SOUTH HOLLAND DISTRICT COUNCIL

Purpose: To consider Planning Application H09-0307-22

Description: Residential Development - Erection of Dwelling

Location: Chancery Lane Holbeach Spalding

SOUTH ELEVATION

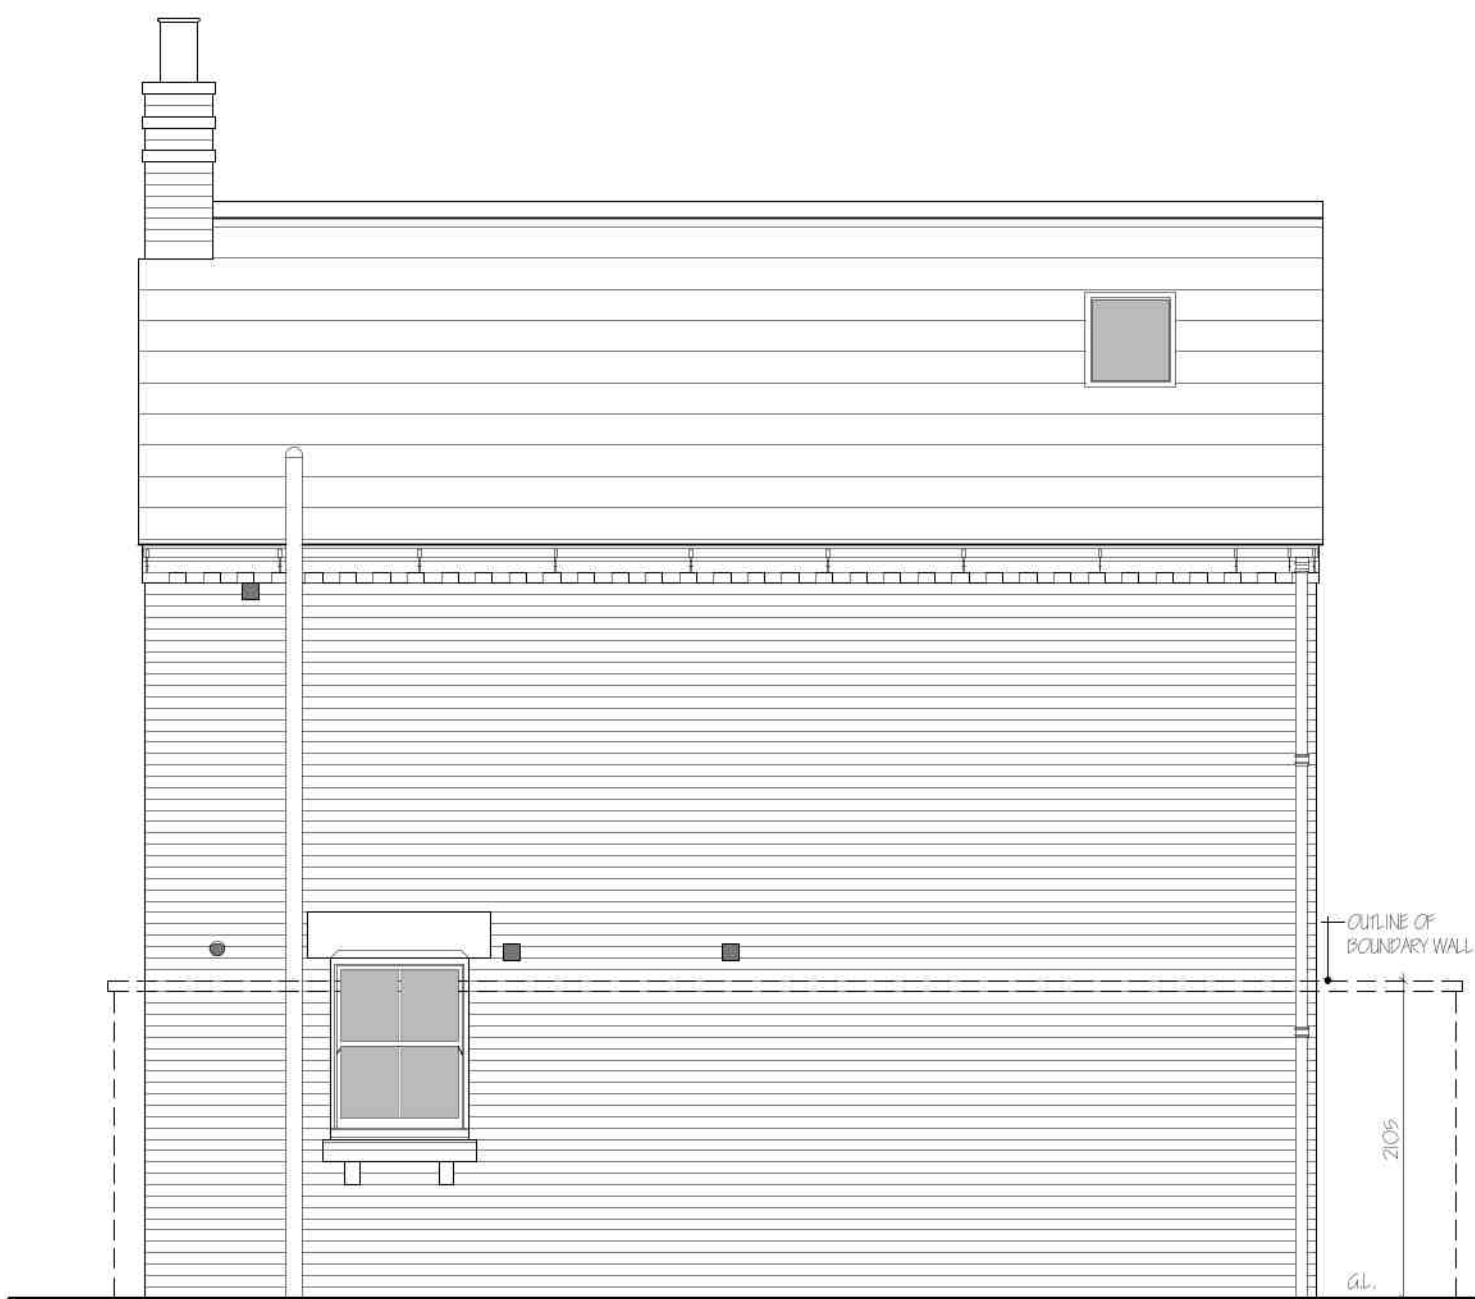
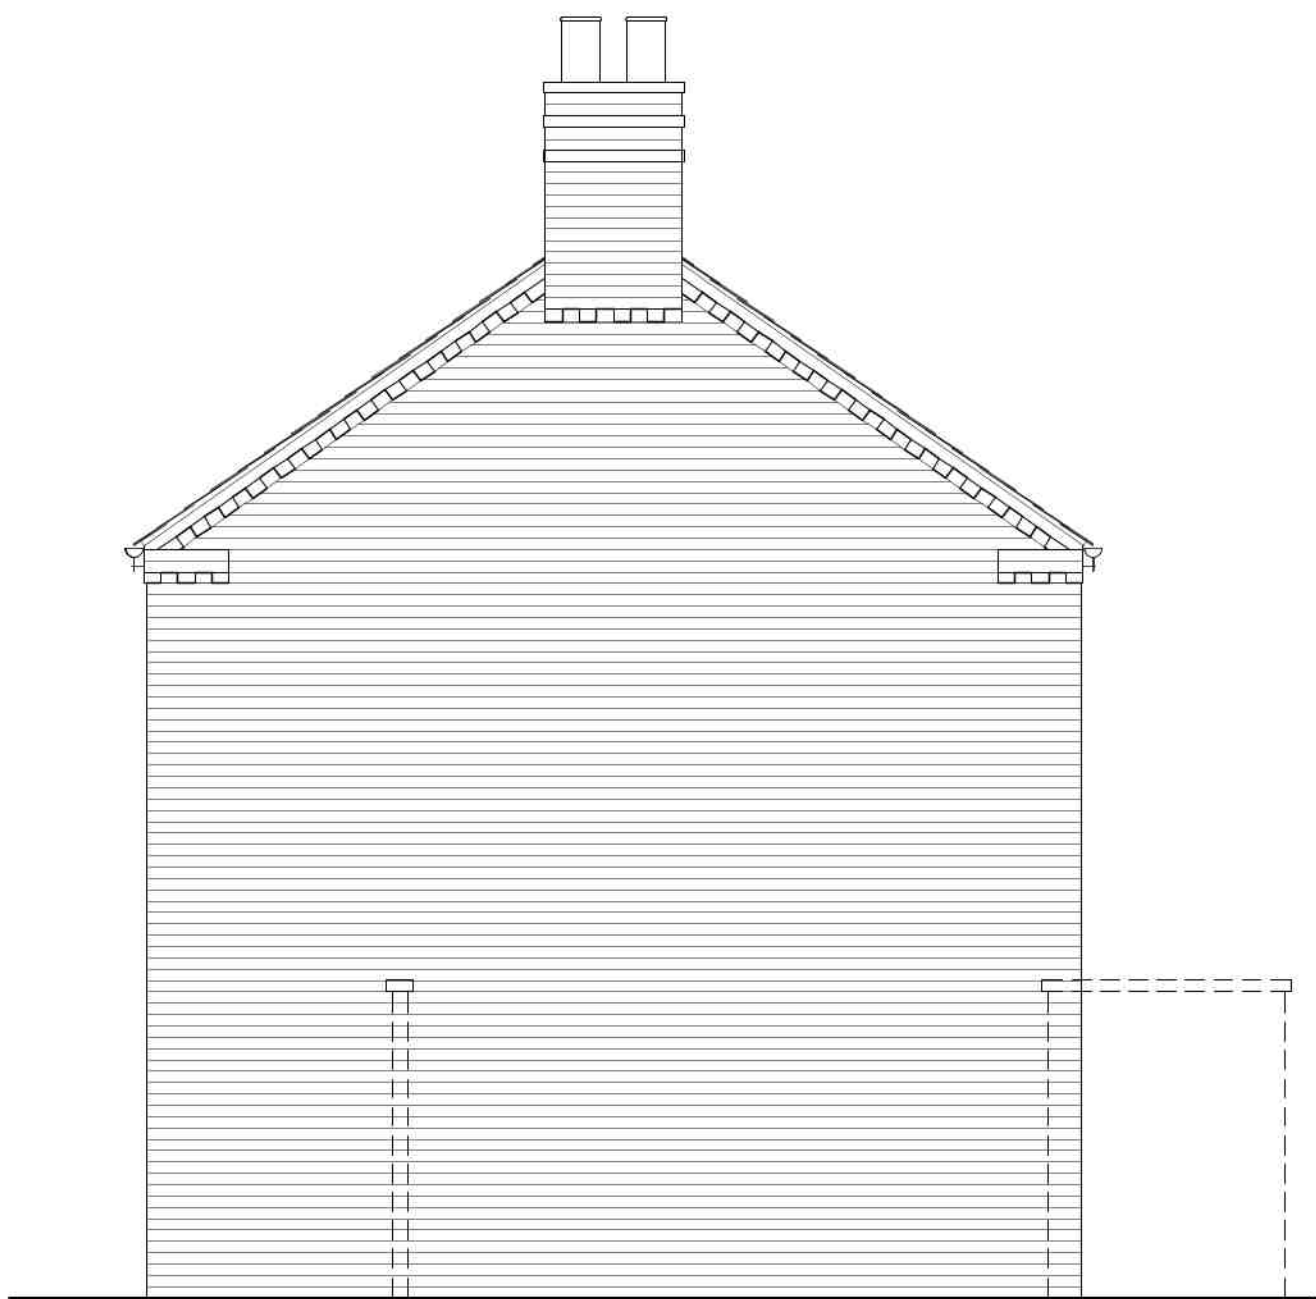
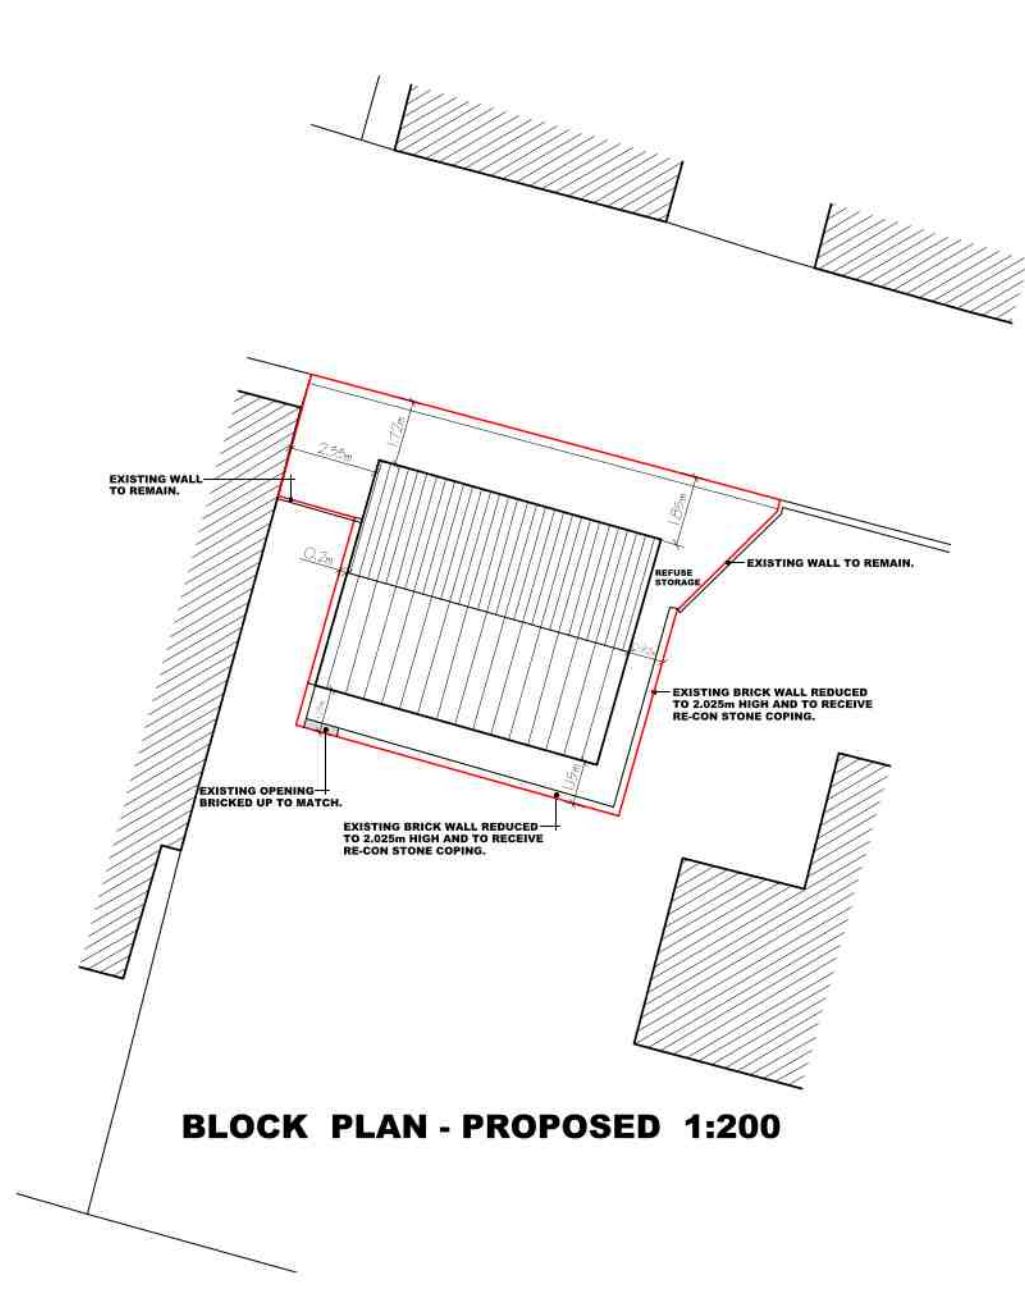
Having spoken again with neighbouring properties, who are understandably upset about the application due to the privacy issue - in my view the easiest solution to this application and to minimise the biggest issue for nearby properties would be to remove the kitchen window in the south wall therefore removing the main privacy issues.

If this unfortunately is not an option, then at very least I would suggest that a condition would specify that the glass should be frosted at the top part of the window which would go some way to alleviate the privacy concerns. I would welcome the first option to be considered very strongly please and the 2nd suggestion as a last resort.

- Overlooking/lack of privacy. Living room looks directly into neighbouring bedrooms. Top of rear kitchen window should be frosted glass
- Overshadowing/blockage of light

- 7.17 The dwelling would have no openings at first floor level on its eastern, southern (rear) and western elevations. A roof light serving a rear bedroom would be high level. A ground floor kitchen window is located at the rear facing garden associated with No. 5 Chancery Lane. However, the rear (southern) and side (eastern) brick wall serving the existing building would be retained at a height of some 2m with new capping (total height some 2.1m). An existing opening at the rear would be bricked up. Given that finished floor levels would be set at 300mm and average male adult eye level is approximately 1.65 metres, this would be satisfactory. It is noted that the property has first floor lounge and bedroom windows facing north towards no. 16, which is located directly opposite. However, the separation distance would be approximately 8 metres which is typical of an urban terraced street such as this. The site is close to the town centre where amenity levels are generally lower and ambient noise levels are higher than average due to traffic noise and general activity. It is considered that the amenity of neighbouring residents would not be materially harmed in terms of overlooking, lack of privacy, overshadowing, blockage of sunlight, overbearing effect or noise and disturbance.

BLOCK PLAN - PROPOSED 1:200

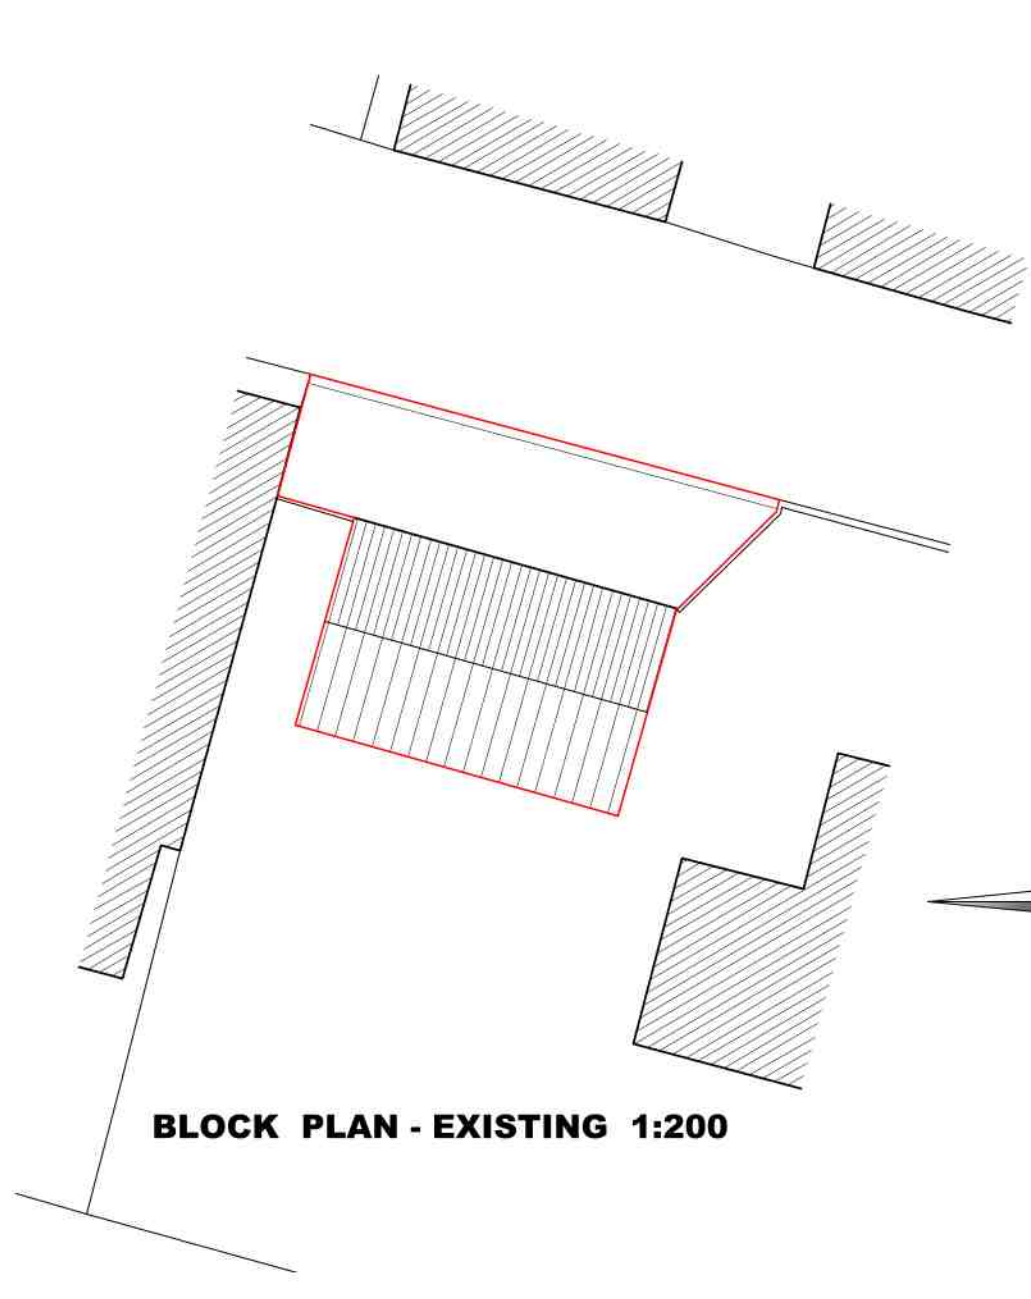
- Entry and egress from Chancery Lane onto Barrington Gate is very tight and visibility is poor
- Very little amenity space. No provision for storage and recycling of refuse bags
- Double garage door in existing rear wall should be bricked up to match
- Why is fencing proposed along eastern boundary as opposed to retention of the existing wall
- No room for footings, scaffolding and maintenance
- How will neighbouring properties be made safe during construction period?
- What arrangements will be made for the removal of asbestos?
- No room for new footings along western elevation due to existing wall
- No fire escape to back bedroom

- 7.29 Other Matters
- 7.30 In terms of whether there is room for new footings along the western boundary, a section of the existing wall along the western elevation will be removed. In any case, it is a matter that falls within the Building Regulations. Issues relating to access onto neighbouring land for scaffolding and maintenance, etc are the subject of separate legislation. The developer has a legal responsibility to carry out works without causing damage to neighbouring property, which would

8. The scheme of boundary screening/treatment, including bricking up of the existing opening within the rear wall, shall be fully implemented in accordance with the approved details prior to occupation of the dwelling and shall thereafter be so maintained.
